Thanet Extension Offshore Wind Farm

Annex A to Appendix 3 to Deadline 2 Submission:
Tabular Responses to Shipping and Navigation
Written Representations

Date: February 2019

Figure 1: Site Location, Wind Farm layout and Pilot Stations.

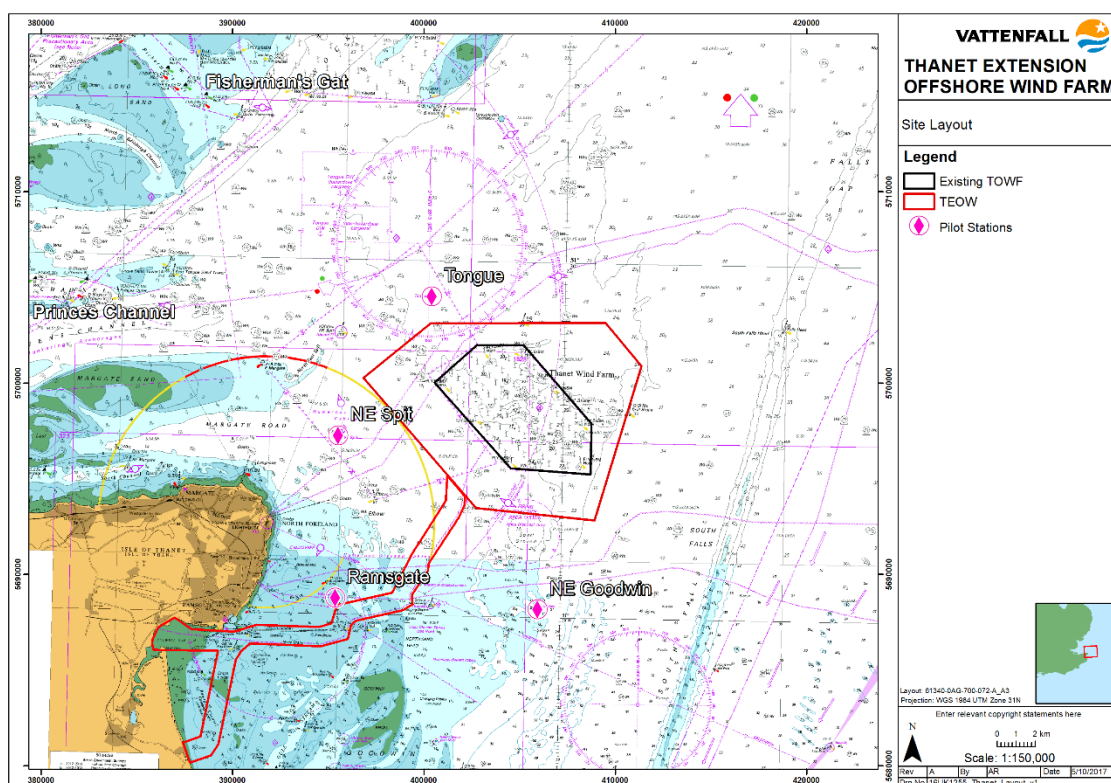
6.6	<p>Pilot Transfer Bridge Simulation Report: The PLA considers that the ExA cannot rely on the conclusions of the Pilot Bridge Simulation ((Annex 10-2 to the NRA) (Document Reference 6.4.10.2)) to determine whether pilot boarding and landing operations could safely continue in the area of the NE Spit boarding and landing diamond with the proposed extension in place.</p>	<p>The Applicant agrees that the simulation in and of itself does not confirm the safety of the operations given the subsequent need to undertake an NRA to assess safety. Notwithstanding that the simulation demonstrated that pilot boarding and landing operations can viably continue in the area, the Applicant notes that the wider assessment and supporting studies as set out the NRA, support the findings that pilotage is both feasible and safe.</p>

6.7	<p>Pilot Transfer Bridge Simulation Report: The extent to which the Simulations represented real world conditions is very limited. The vessels were all ‘manned’ by experienced PLA pilots who are all very familiar with the NE Spit area. The vessel models used were</p>	<p>The Applicant notes that detailed response is provided to these points within the response to the ESL Written Representation in items 6.6 to 6.16. However, the capability of the PLA simulator is</p>

WR point	WR	Response
	<p>all ‘well found ships’. The extent to which the PLA simulator can re-create true environmental conditions is limited. It does not represent true darkness and does not give a true impression of the weather that may be being experienced. The simulation runs undertaken did not represent the full range of environmental conditions, e.g. wind strength and direction in which the pilot cutters are able to operate, using a maximum of 25 knots. The simulator does not have a model of a pilot cutter so this had to be substituted with a tug, which reacts very differently. The simulations did not fully take into account the lack of local knowledge of a Master bringing his vessel to the NE Spit for the first time; the potential lack of understanding of the cutter’s requirements due to the limitations of their ability to communicate in English; the potential for delays during the boarding and landing due to poorly/incorrectly rigged pilot ladders. No emergency scenarios were simulated and the simulations did not include the range of small vessels such as recreational vessels and crossing traffic, such as windfarm support vessels that may be found in the area.</p>	<p>considered, by the PLA, to be “highly advanced” and “Pilots can test out and perfect manoeuvres against a background of the highest wind speeds and worst weather” (Source PLA Handbook 2018) and therefore the Applicant considers that the simulator and the conditions it represented is not ‘limited’.</p> <p>With respect to <i>‘the potential for delays during the boarding and landing due to poorly/incorrectly rigged pilot ladders’</i> the Applicant notes that these scenarios were identified from the outset and incorporated into some of the simulations runs and furthermore the assessment criteria (Section 4.2 of Appendix 4 to the Applicant’s Deadline 2 Submission) also included a criterion (no 6) relating to the ships capacity to respond to an emergency. This was addressed systematically in each run debrief.</p> <p>It is noted that the passage of some third party vessels was included albeit did not form the focus of the assessment as complex vessel interactions were reviewed quantitatively under the collision risk modelling.</p>

Sea Zones Plan – Reduction in red line boundary

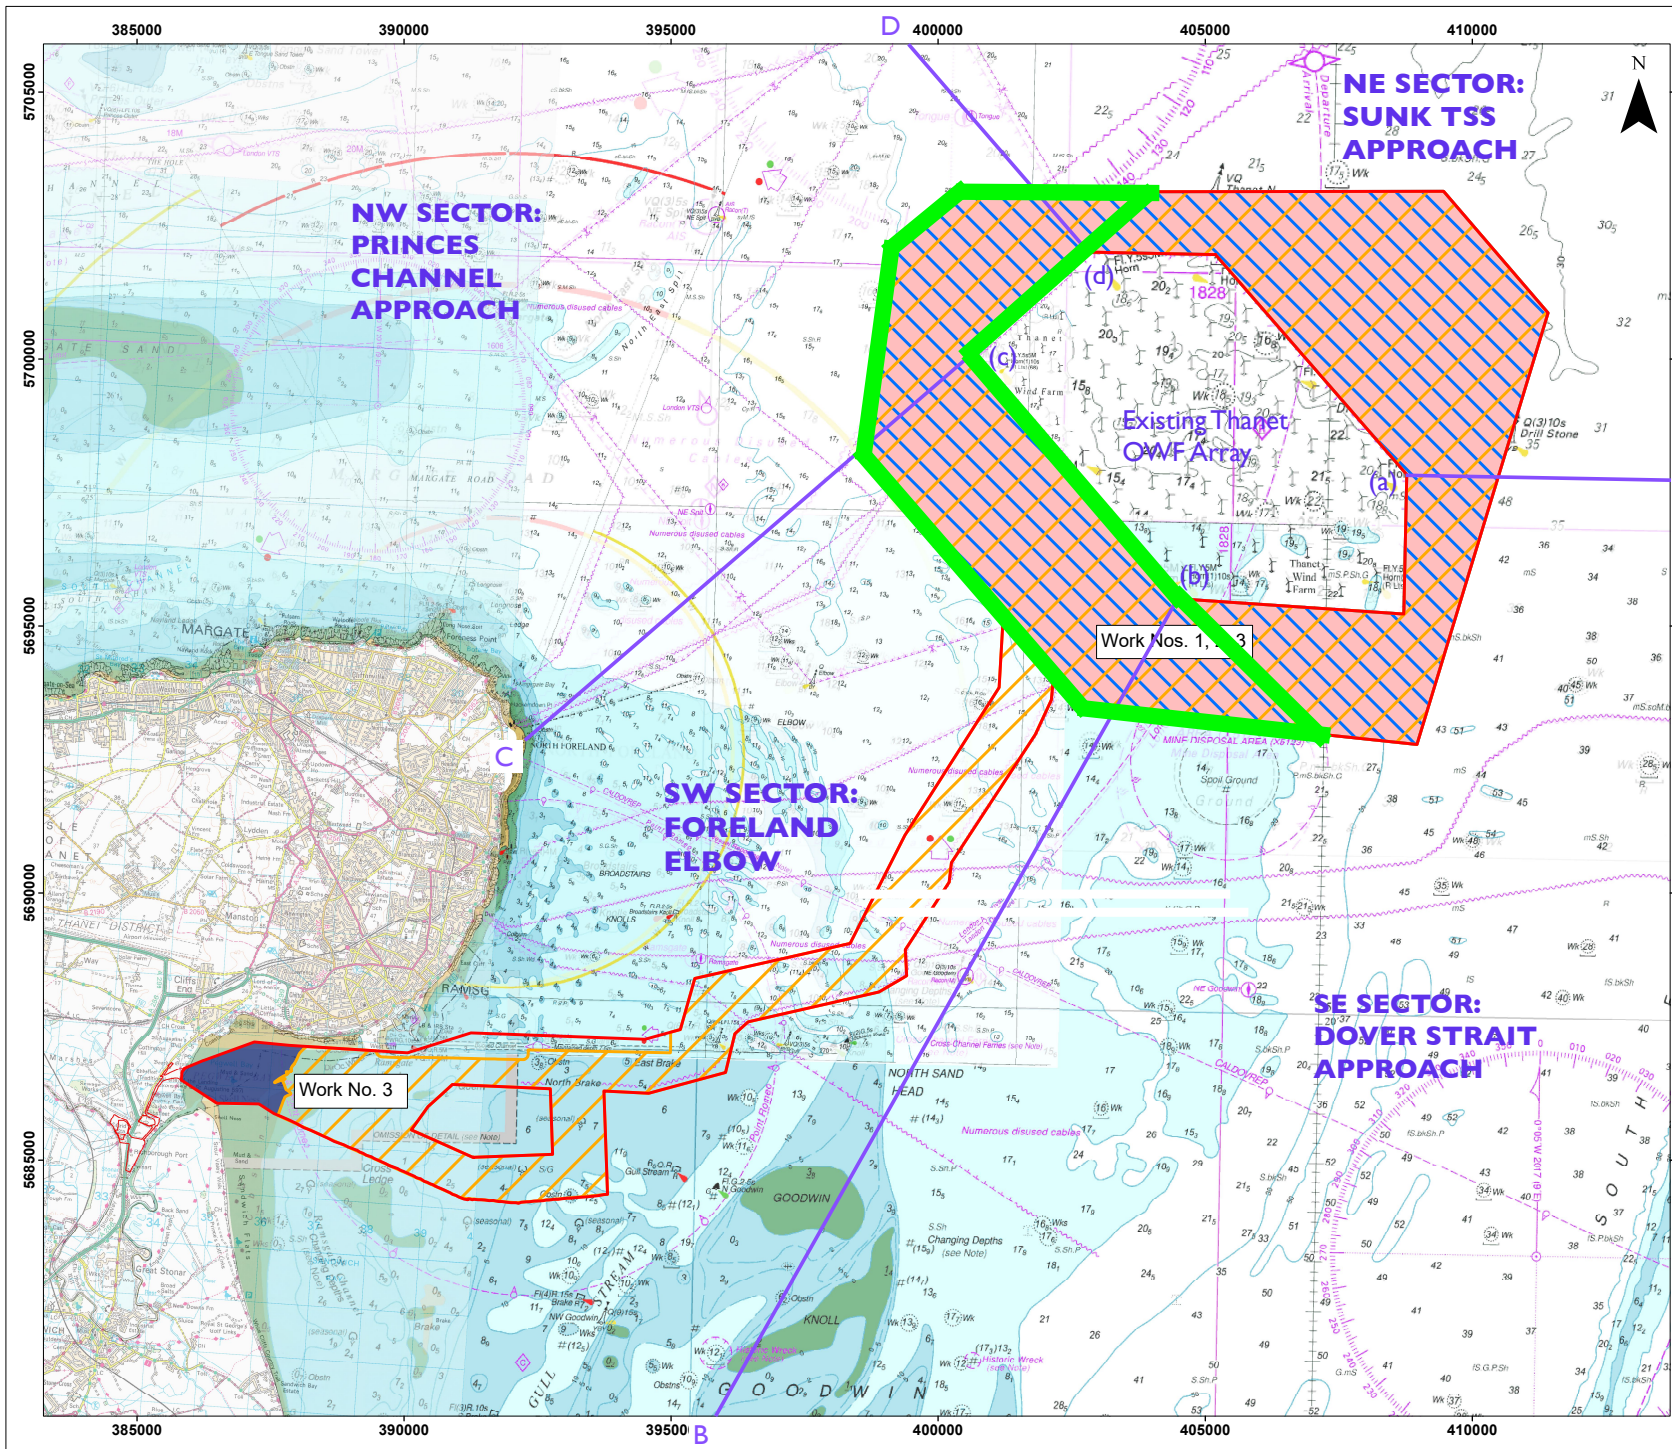
7.1	<p>Desired mitigation</p> <p>The mitigation desired by PLA is a further reduction in the Red Line Boundary of the application at the Western boundary of the site. Although the Applicant has already proposed a reduction in the Red Line Boundary, it is the position of PLA that this is insufficient to address its concerns about navigational safety. PLA’s desired revised Red Line Boundary is illustrated on the Sea</p>	<p>The Applicant is cognisant of PLA’s request to undertake further reduction in the Red Line Boundary of the application at the Western boundary of the site.</p> <p>It is the Applicants position however, that without an evidential basis for further reduction and a total reliance on “qualitative” judgement (amongst the</p>

WR point	WR	Response
	<p>Zones plan included with these Written Representations as Appendix 1. This plan illustrates the area of the proposed extension which PLA requests be removed from the DCO edged in green. Reducing the area of the proposed red line boundary to this extent would address the PLA's concerns with the Scheme.</p>	<p>lowest level of evidence on the evidence hierarchy), it is not possible for the Applicant to reduce the RLB further.</p>
